PLANNING PERMISSION

APPLICATION NO: 3/2021/0586

DEVELOPMENT PROPOSED: Proposed addition of window to south elevation, replacement of existing roof lights with larger conservation type velux windows and removal of chimney stack to accommodate internal alterations. Resubmission of 3/2021/0167.

AT: 2 Bridge End Whalley Road Billington BB7 9NU

PROPOSED
ELEVATIONS

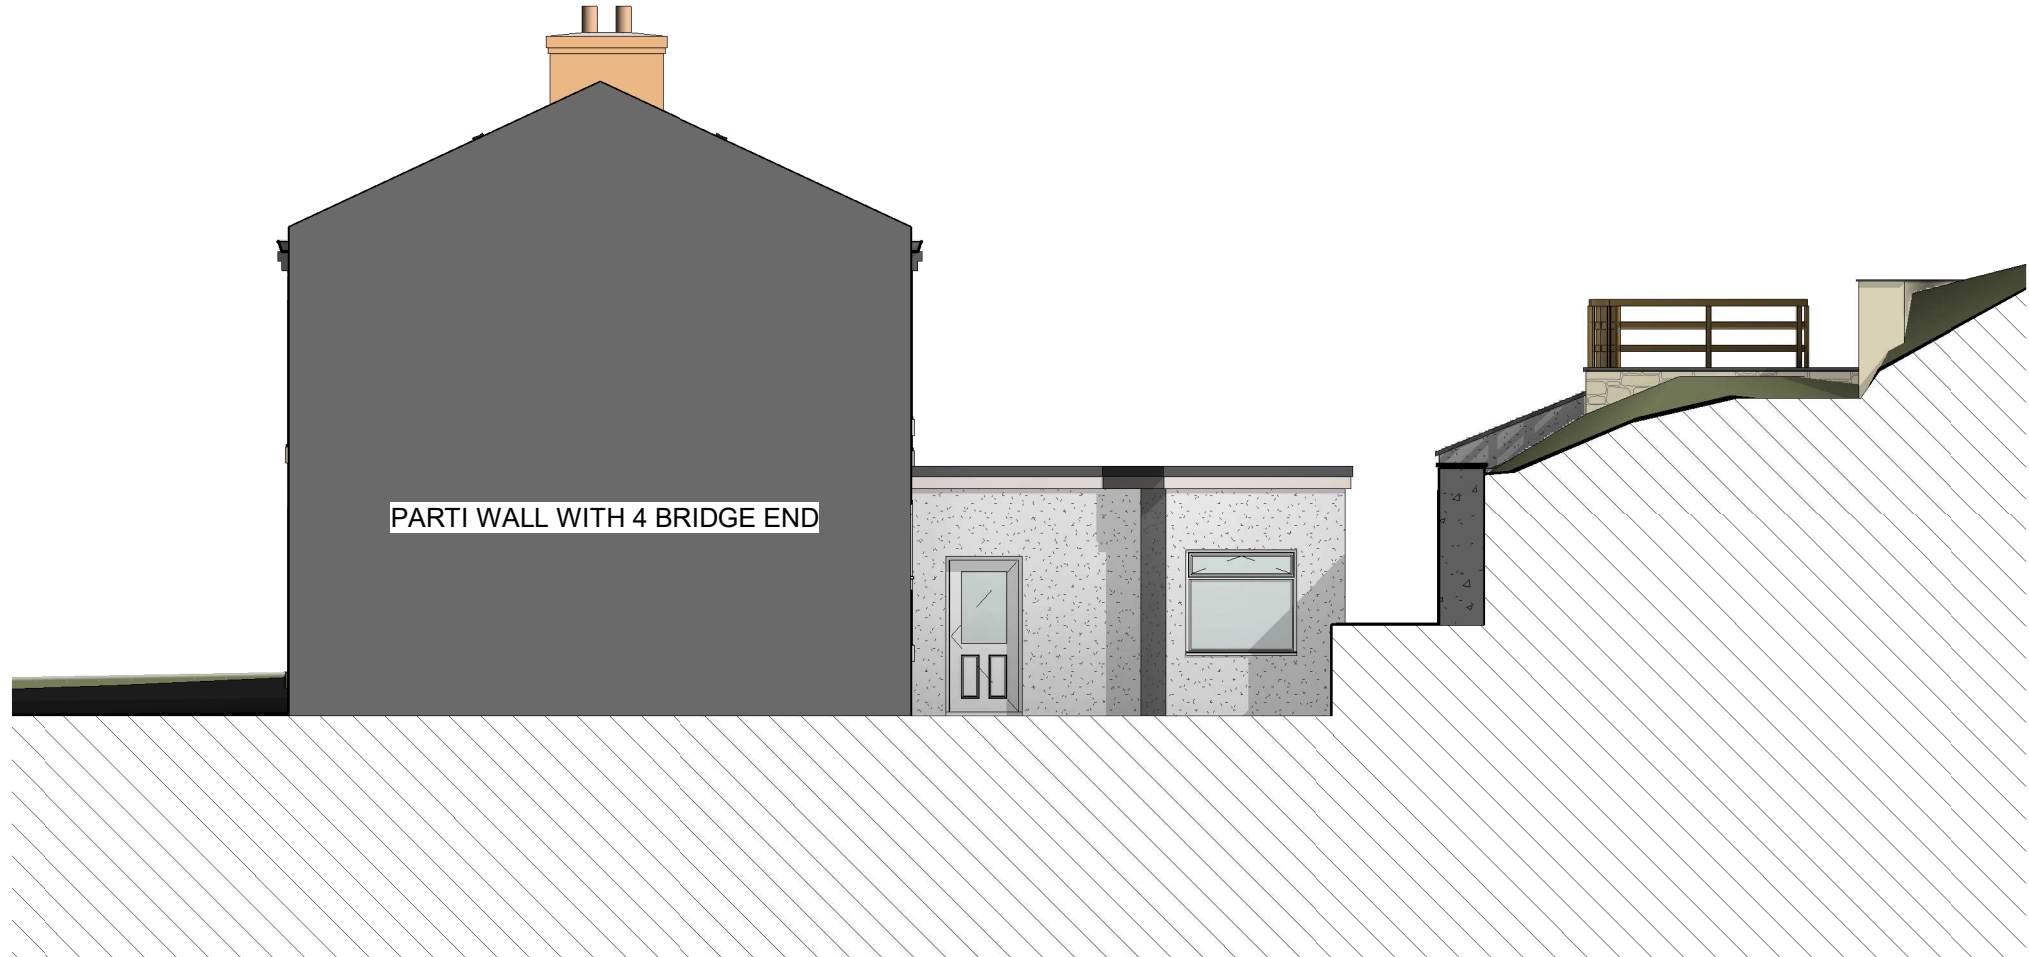
4. Notwithstanding the details shown on the approved plans, the proposed Velux roof lights shall be of Conservation Type, recessed with a flush fitting, and shall be retained as such in perpetuity.
